CITY OF ALBUQUERQUE

April 3, 2019

**RE: Highland High School Title IX Gymnasium Upgrade-Phase 2, 4, 5 & 6
4700 Coal Ave SE
Requested Permanent C. O. – Accepted
Engineers Stamp Date 6/23/16 (K17D021)
Certification dated: 4-1-19**

**C-100**  
SHEET OF

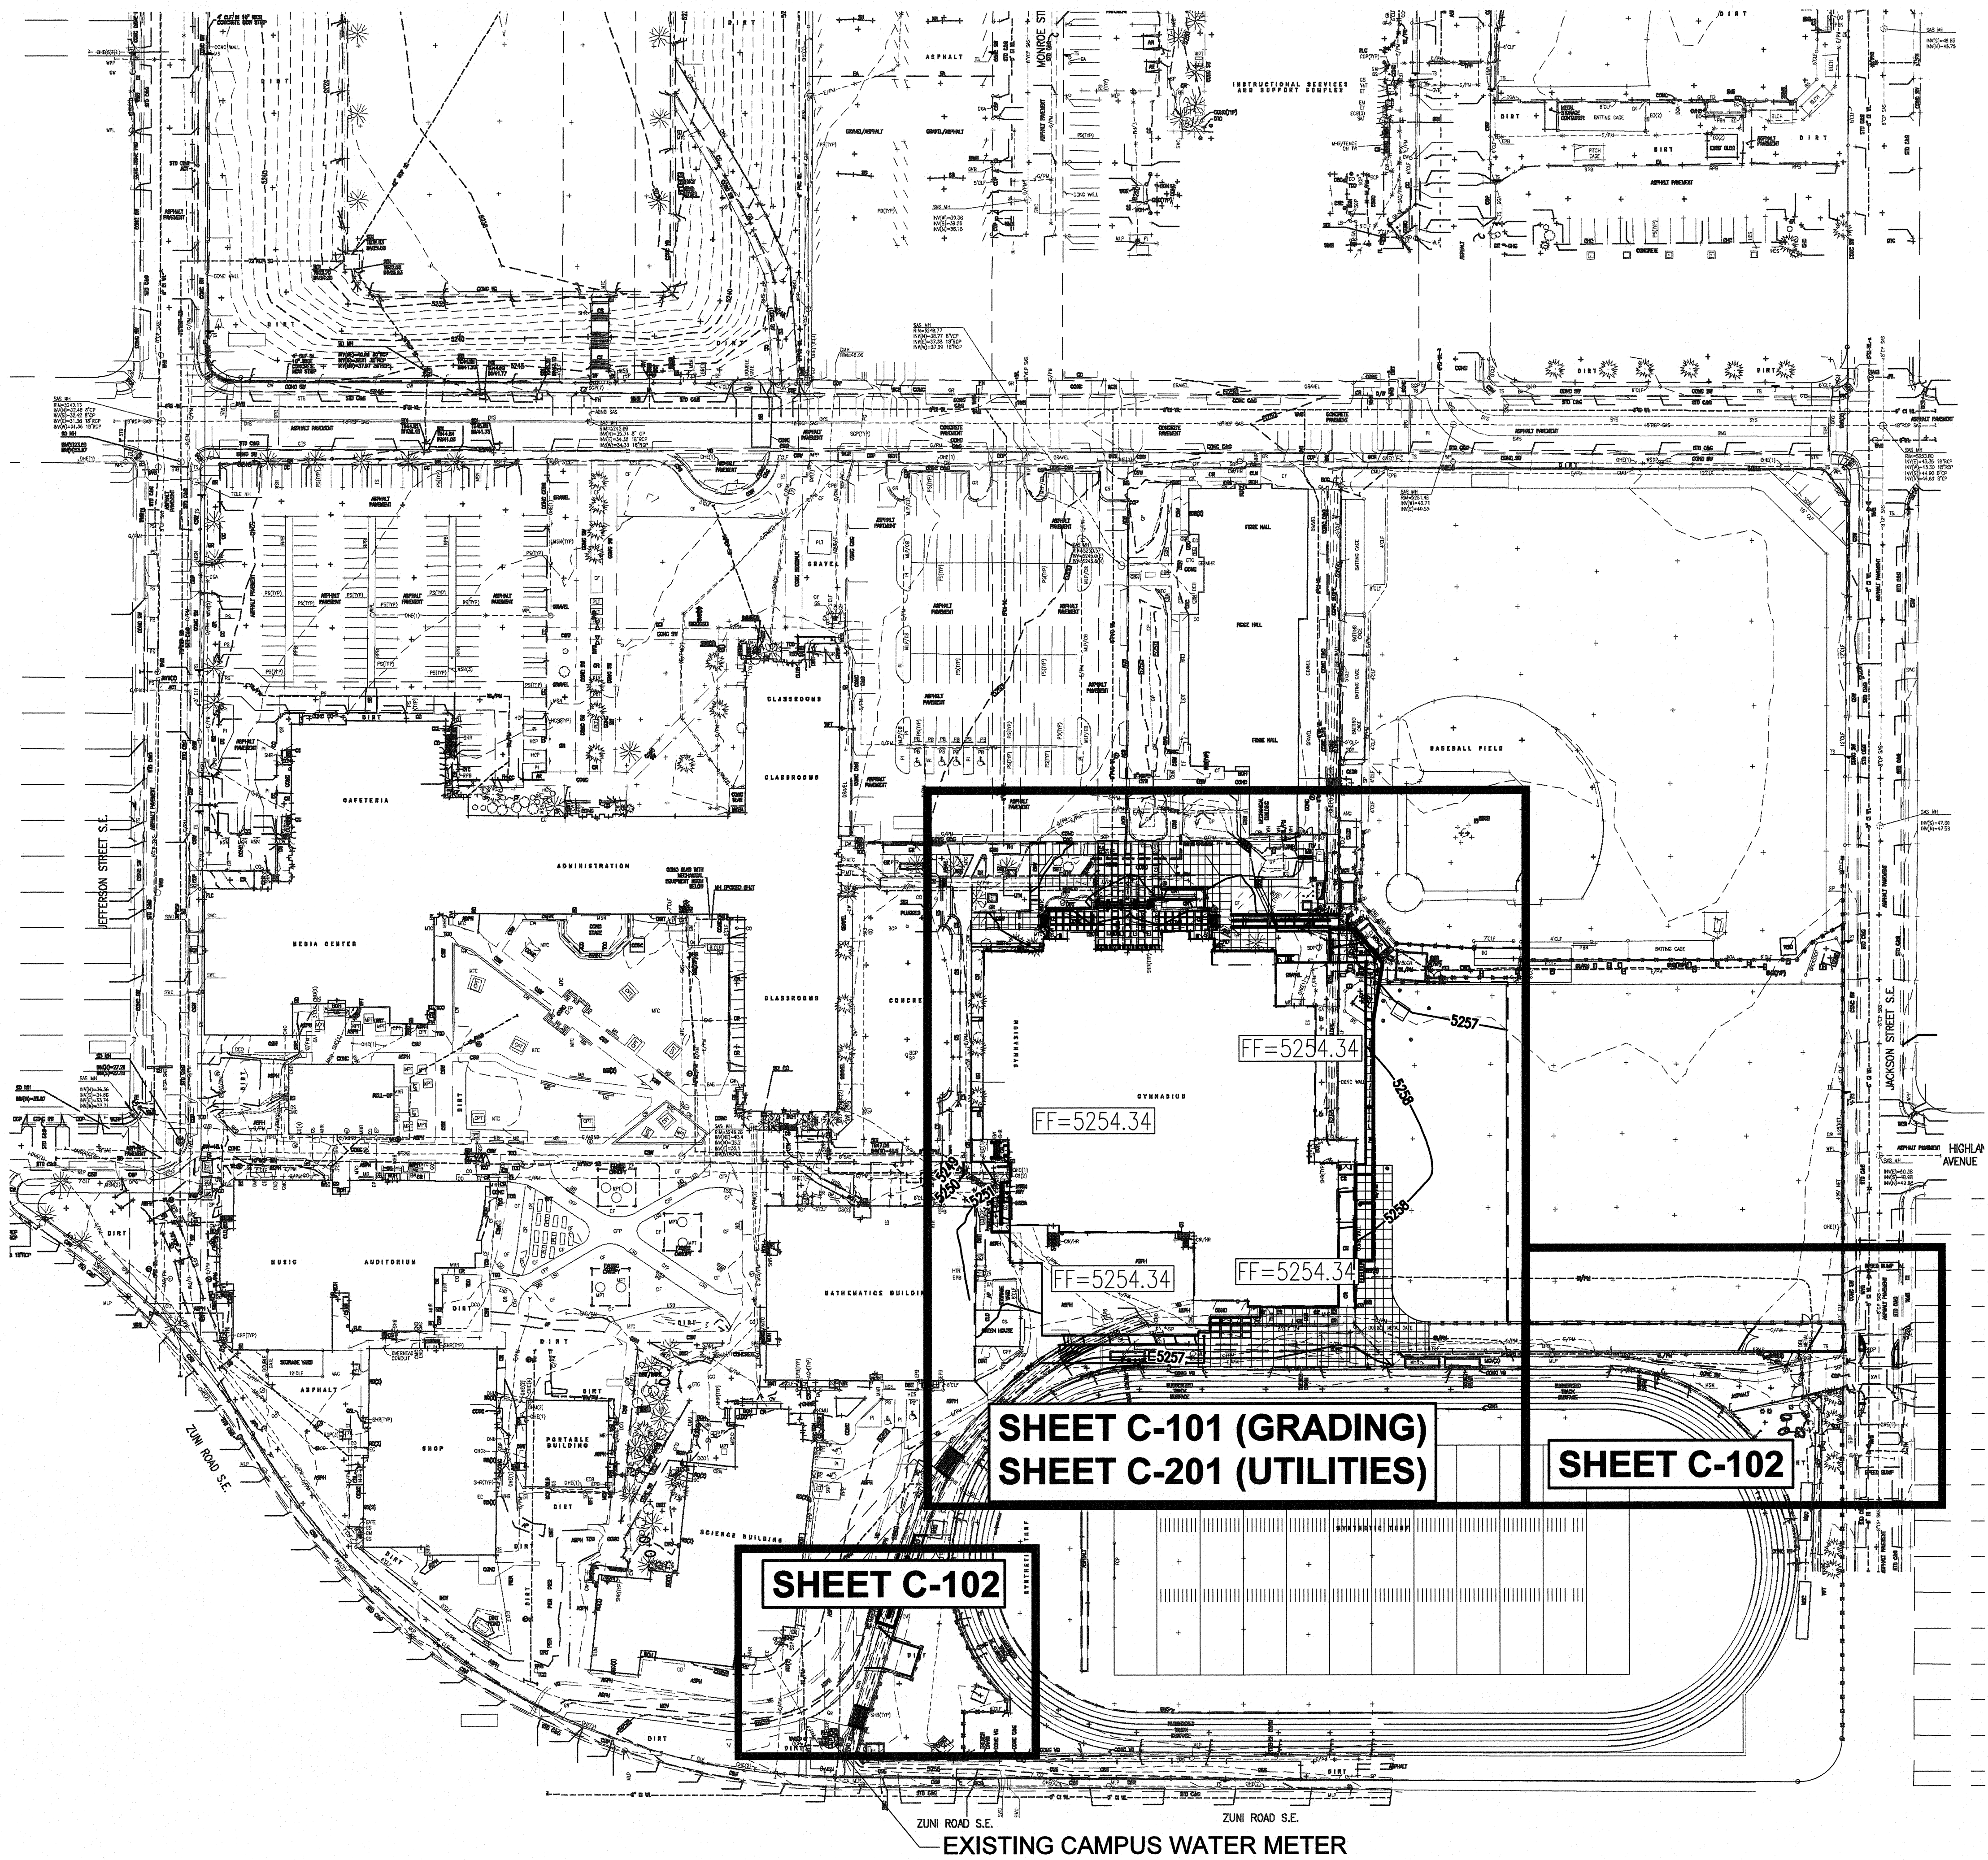
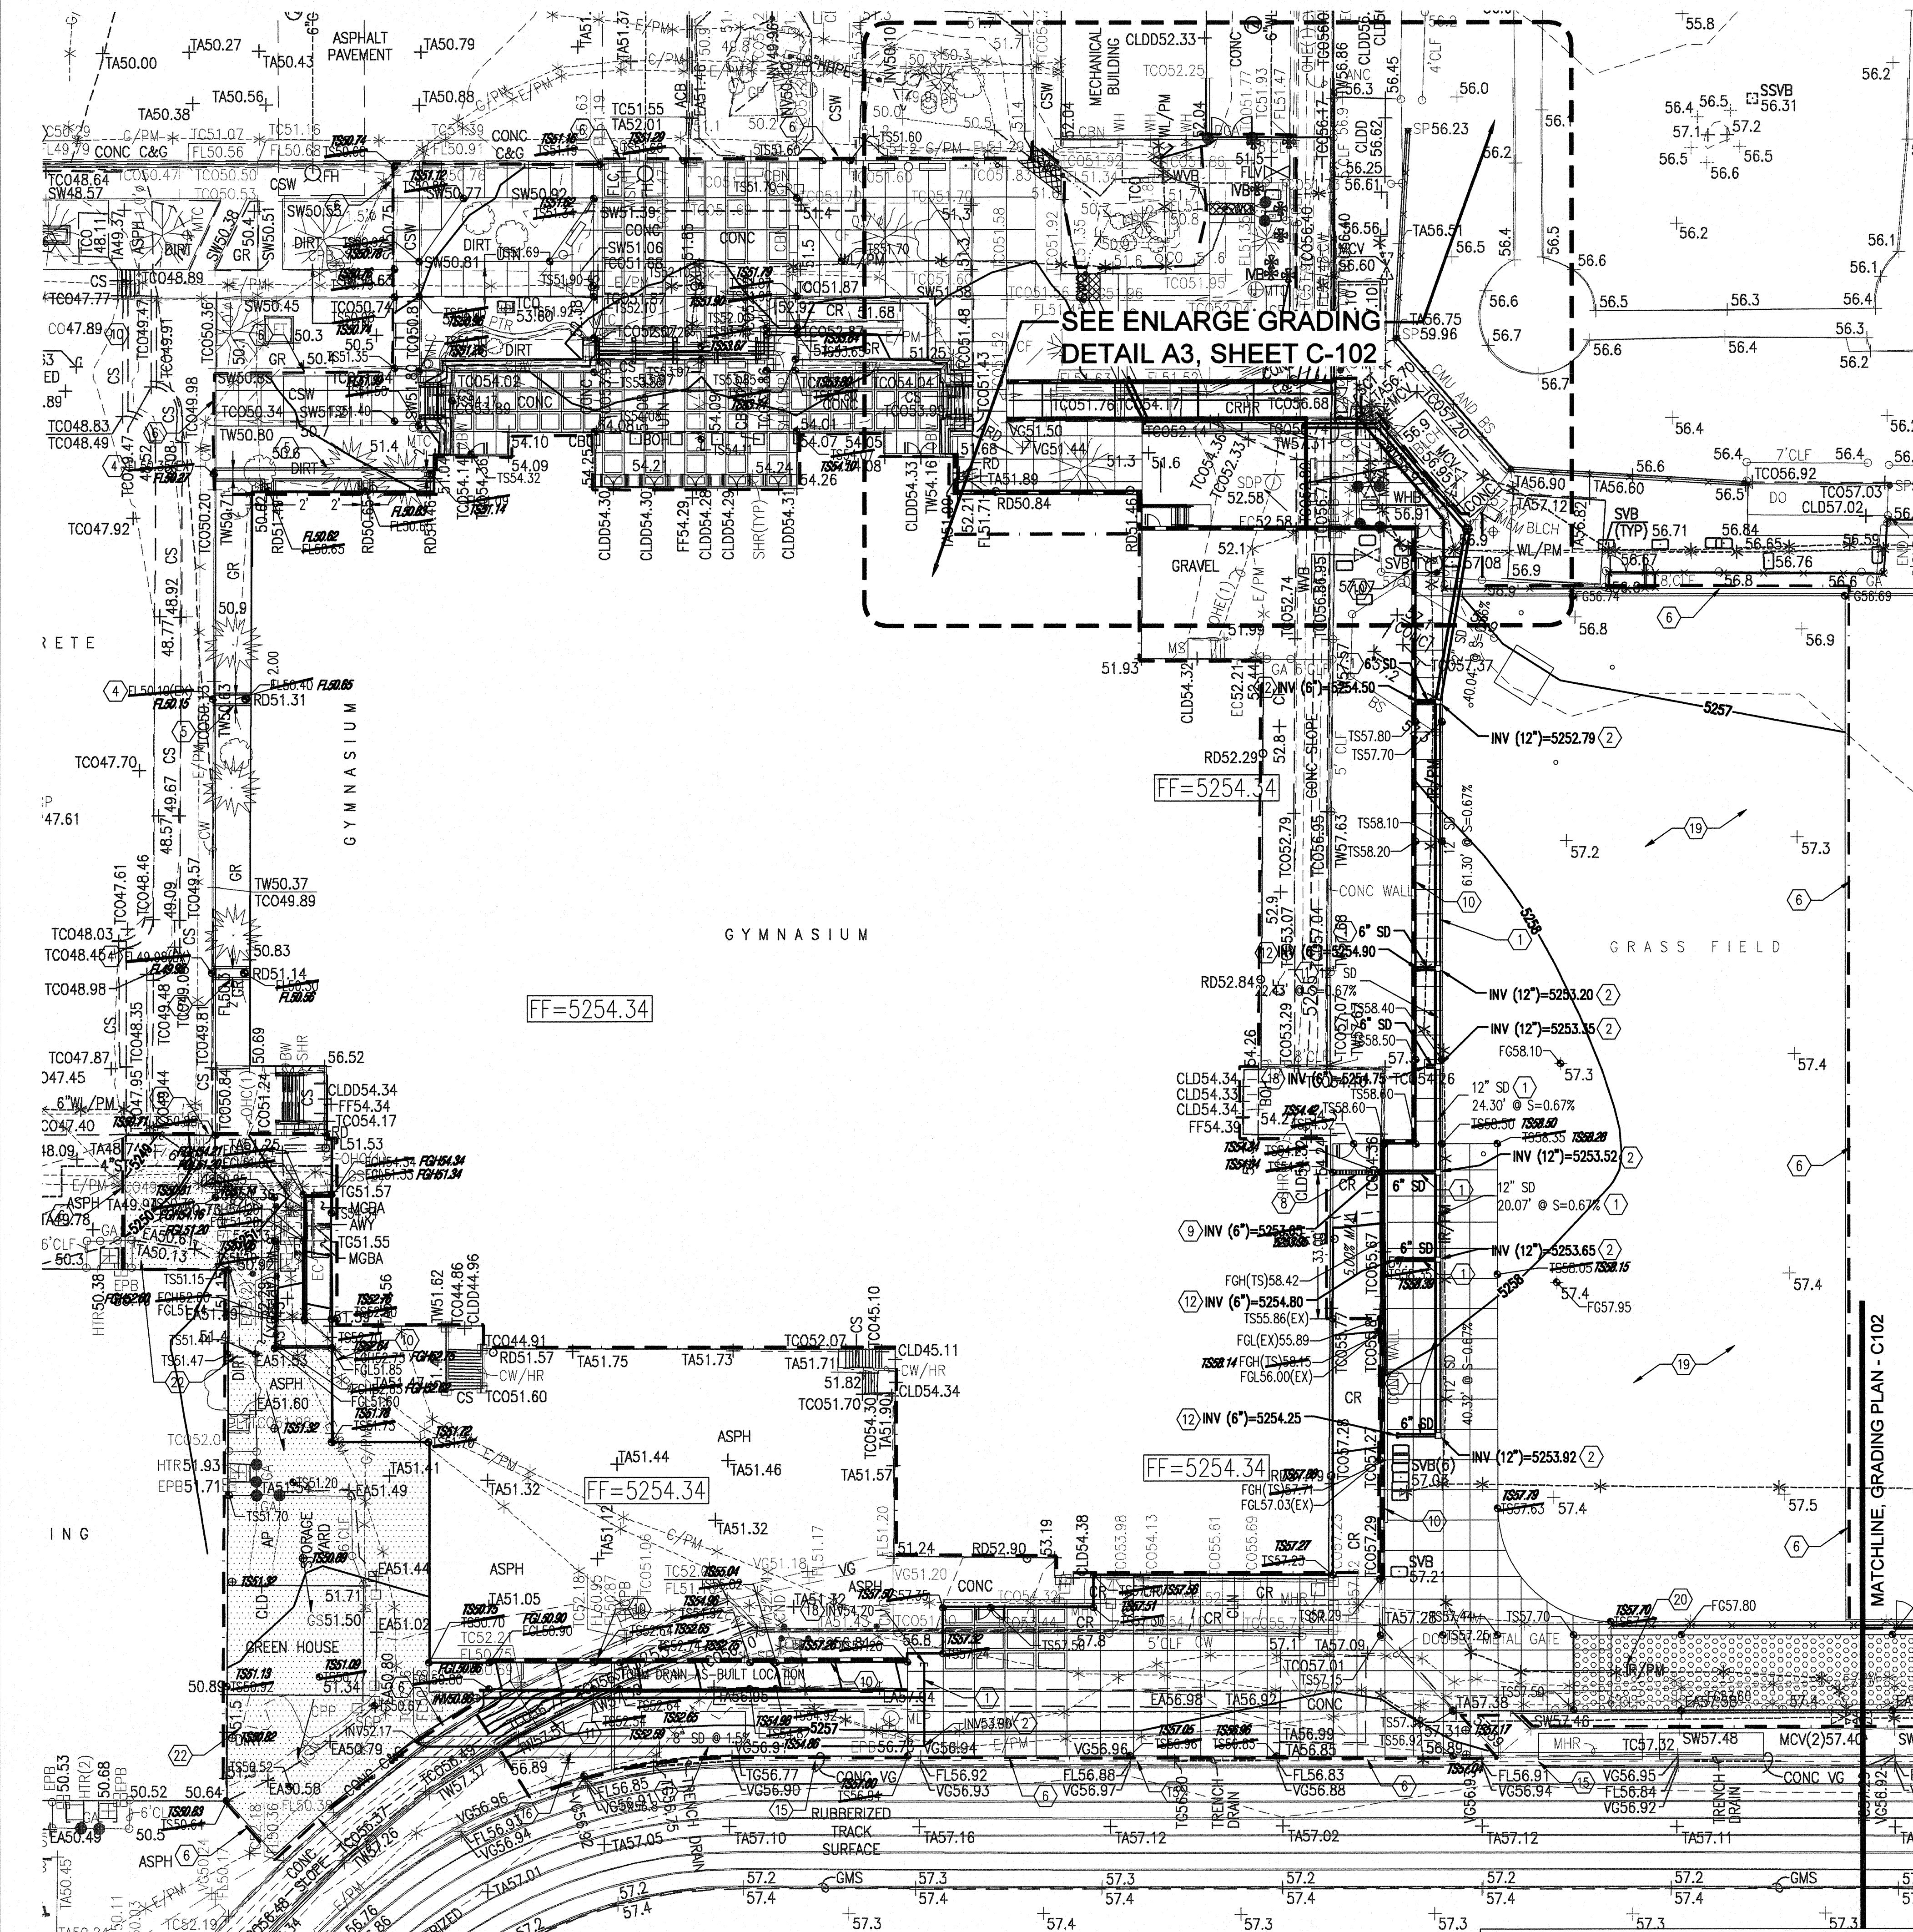
Before Phases 1 and 3 can be accepted for a permanent CO the following comments must be addressed.

- All construction fencing is to be removed from Phase 3. See attached pic.
- The roof drains need to be connected to the down spouts in Phase 3.
- Note 15- Clean existing trench drain clear of debris and ensure proper function.
- Plates on all sidewalk culverts need to be bolted down in Phase 1.
